**Consultation Response from KC,
Ecology Unit**

2026/91664 adj, 5, Fernside Avenue, Almondbury, Huddersfield, HD5 8NR

Demolition of existing building and erection of dwelling

Date Responded: 09/07/2026

Drawing Title
Existing Plans, Site Sections & Elevations

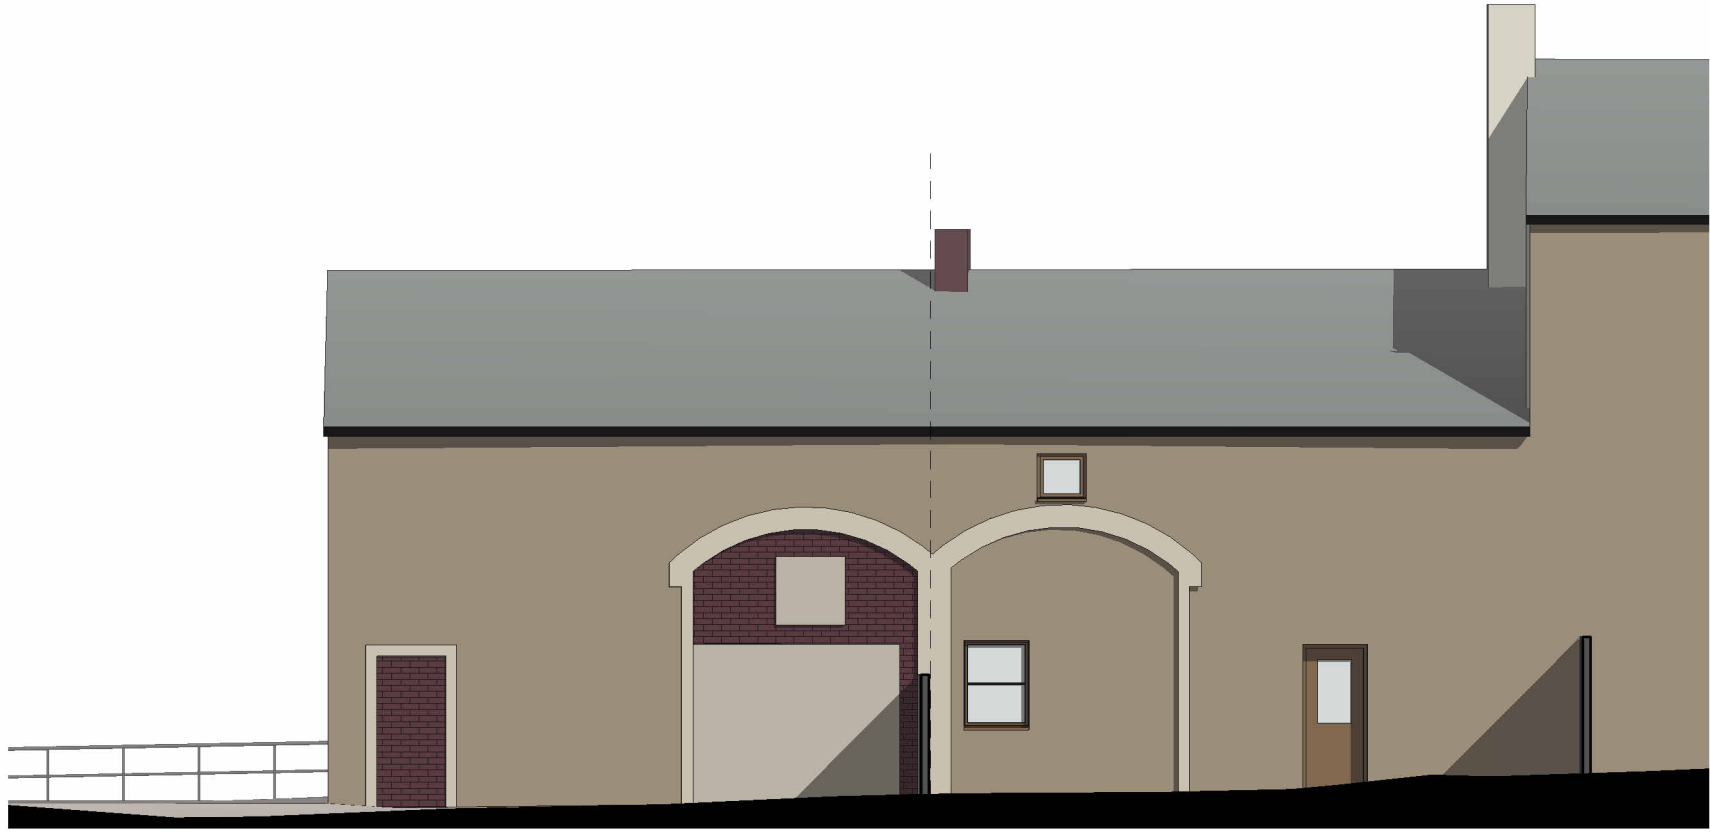
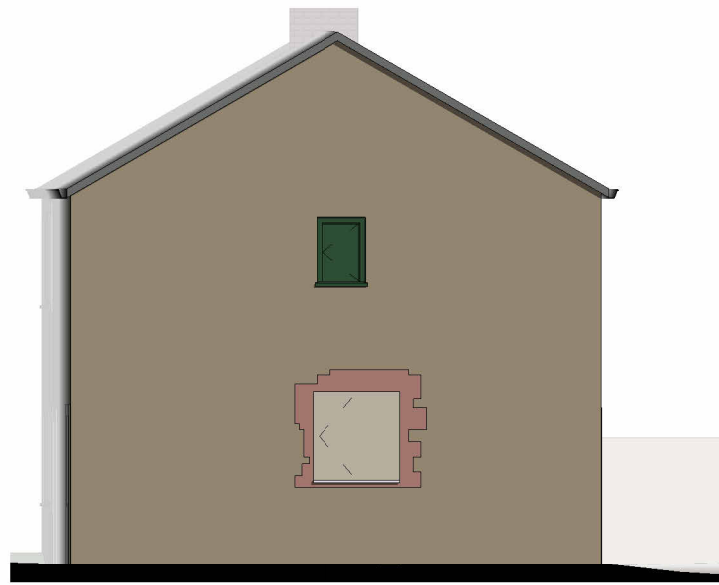
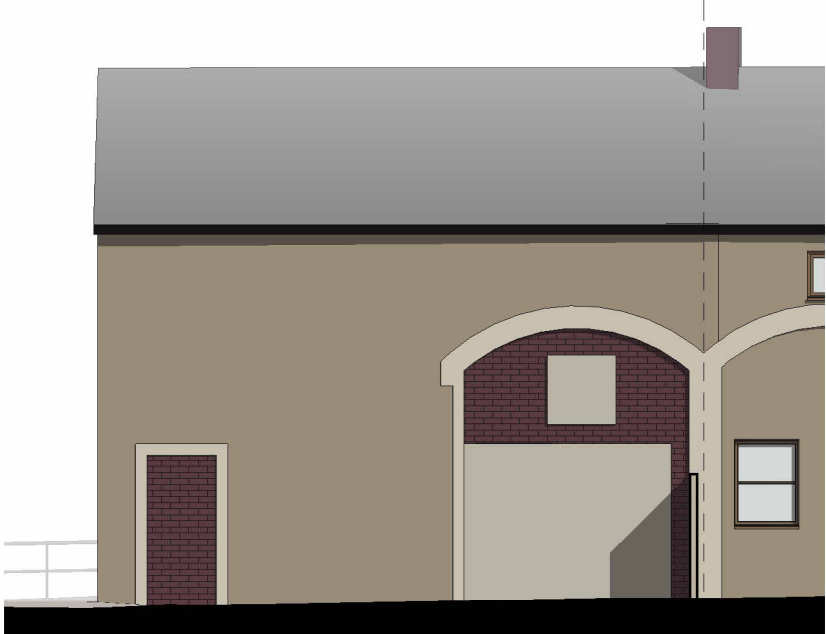
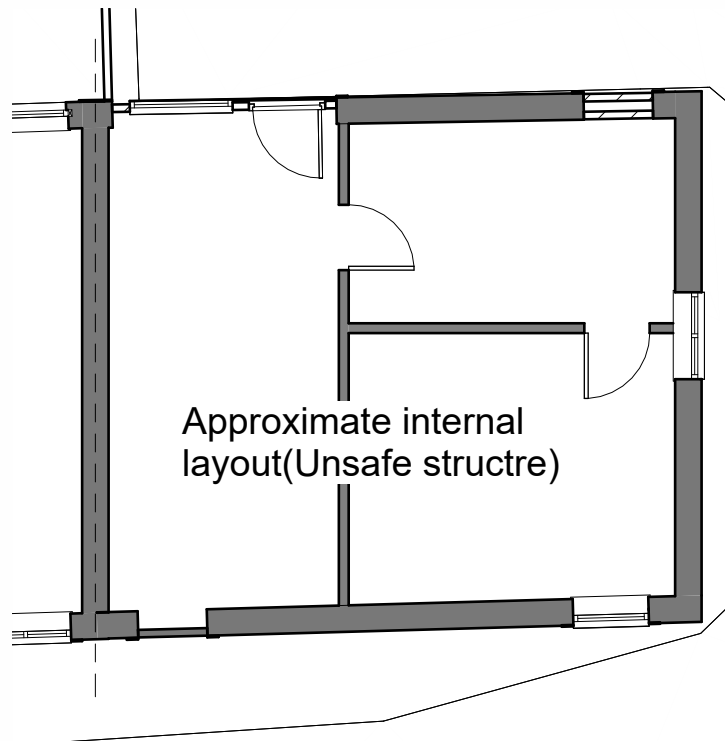
I have reviewed the information submitted with this application, and further ecological information should be submitted. The submitted photos show that the building could be suitable for roosting bats, and a bat survey report submitted as part of the previous application at this site also concluded that there was Low suitability for roosting bats. I would recommend that a further bat assessment is completed, prior to determination, to ensure that appropriate mitigation and enhancement measures for biodiversity can be included as part of the development. Bats are very mobile species and will readily find new areas to roost.
